**Consultation Response from KC,  
Lead Local Flood Authority**

**2023/90237 Park Gear Works, Park Road, Lockwood, Huddersfield, HD4 5DD**

**Discharge of condition 10 (drainage strategy) of previous permission 2020/91894 for demolition of existing building and erection of engineering building with associated external works**

**Date Responded: 17/02/2023**

Client: David Brown Santasalo
 Project: Marine Assembly 3
 Title: Drainage Layout

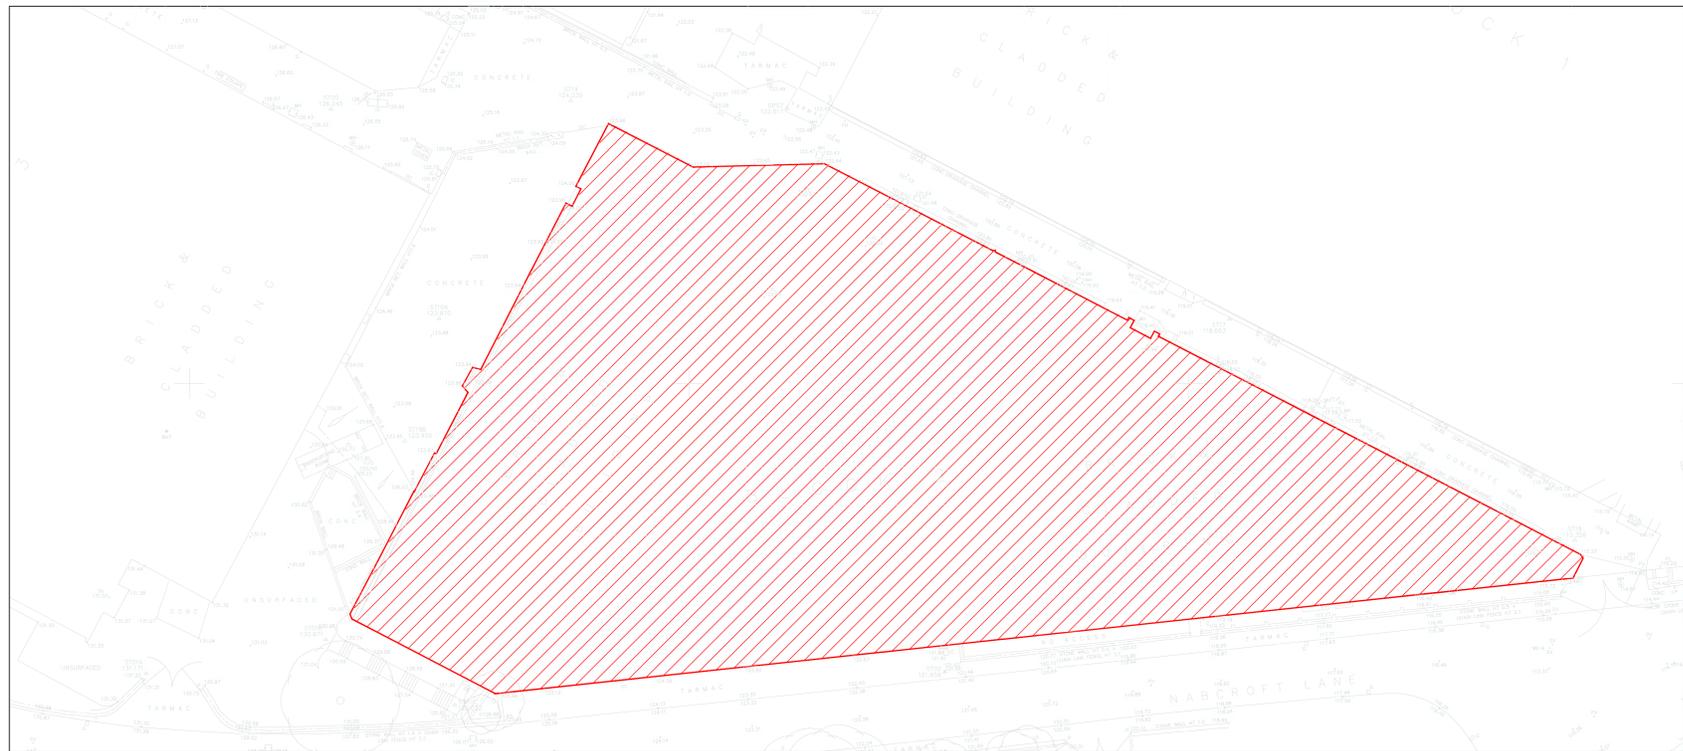
The drainage layout indicates that the surface water drainage from the new building is to be pumped to the outfall drain. The LLFA generally does not allow a pumped solution to disposal of surface water run-off due to the risk of pump breakdown or failure caused by area wide power failure during storms. If the developer wishes to use pumping, then there should be both automatically controlled duty and standby pumps and facilities to power the pumps with a standby diesel generator based on site to be used in the event of mains power failure.

The developer is requesting that the attenuation storage is not provided for Marine Assembly 3 (MA3) Building until the construction of the proposed Marine Assembly 4 building. The planning permission for the proposed building has not yet been granted, therefore the discharge of this condition cannot be given.

Note that revised hydraulic calculations will need to be issued for LLFA approval if attenuation storage is to be provided remote from the MA3 site.
